RE: Response to Department of Planning, Industry and Environment

Lang Walker AO Medical Research Building, Macarthur

DPIE, Transport comments

Figure 2: Original landscape plan illustrating three bicycle parking racks on Parkside Crescent. Source: Turf

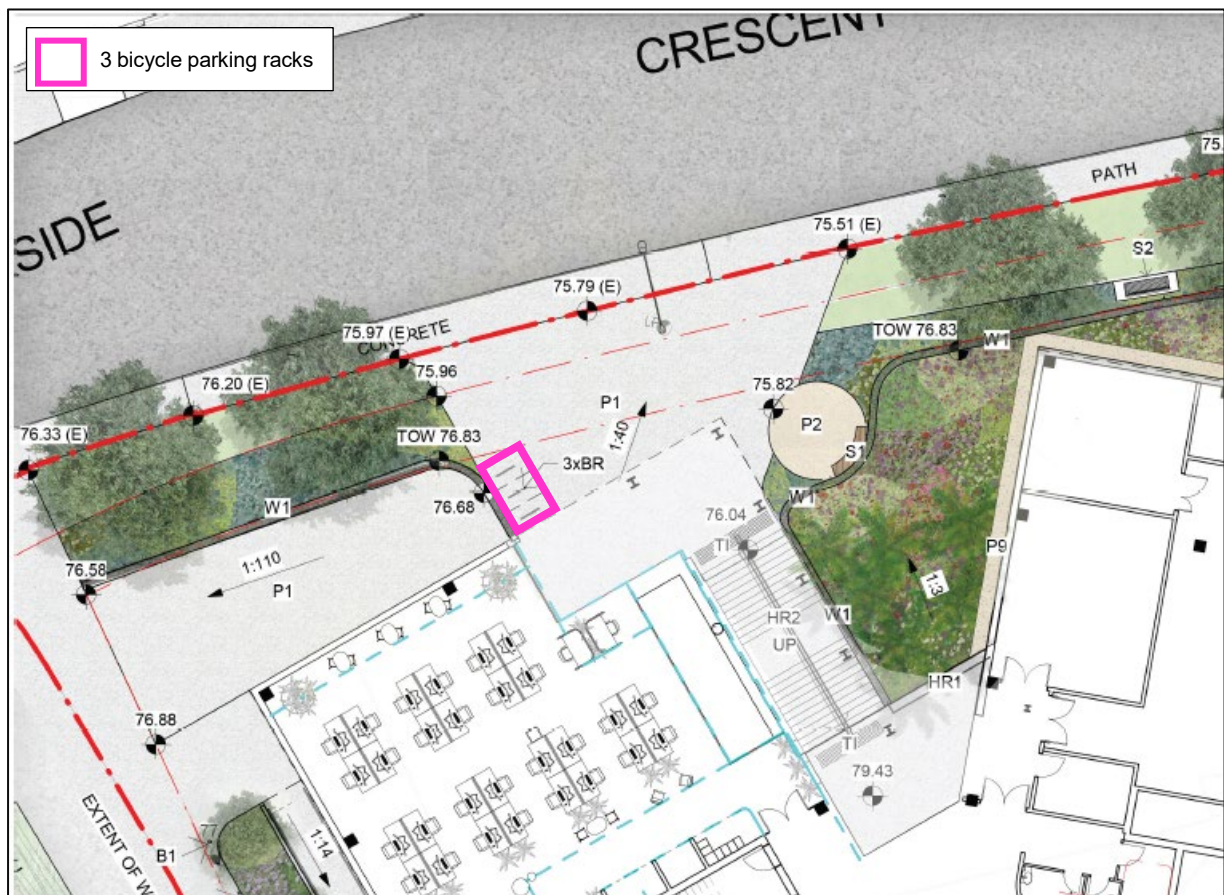
E. It is recommended bike racks be installed near the village green entrance, as this is the main entrance to future proof the redevelopment of a larger village green. Additional bike racks could also be added to the Parkside Entry as only three bike racks have been provided. Bike racks should be installed in multiple locations to make cycling convenient.

Only three bike racks have been added. It would be great to increase the number of bike racks. As shown within the landscape comparison drawing mark-up, additional bike racks could be added by Parkside Crescent. If there is a possibility of bikes or scooters coming from the village green, a few bike racks should also be added within the village green area.

KK. The bike rack area could be extended by about 3 - 4 more racks potentially.

Response: The majority of cyclists will be arriving from Parkside Crescent as there are existing cycle paths through and away Marsden Park adjacent to Parkside Crescent. An additional three cycle parks have been added totaling six bike racks (12 parking spots). The hospital does not have an internal cycle network or a cycle path that leads to the main entry. Cycle parking is not recommended at the village green.

Response: An additional three bike racks totaling six bike racks (12 parking spots) have been added.
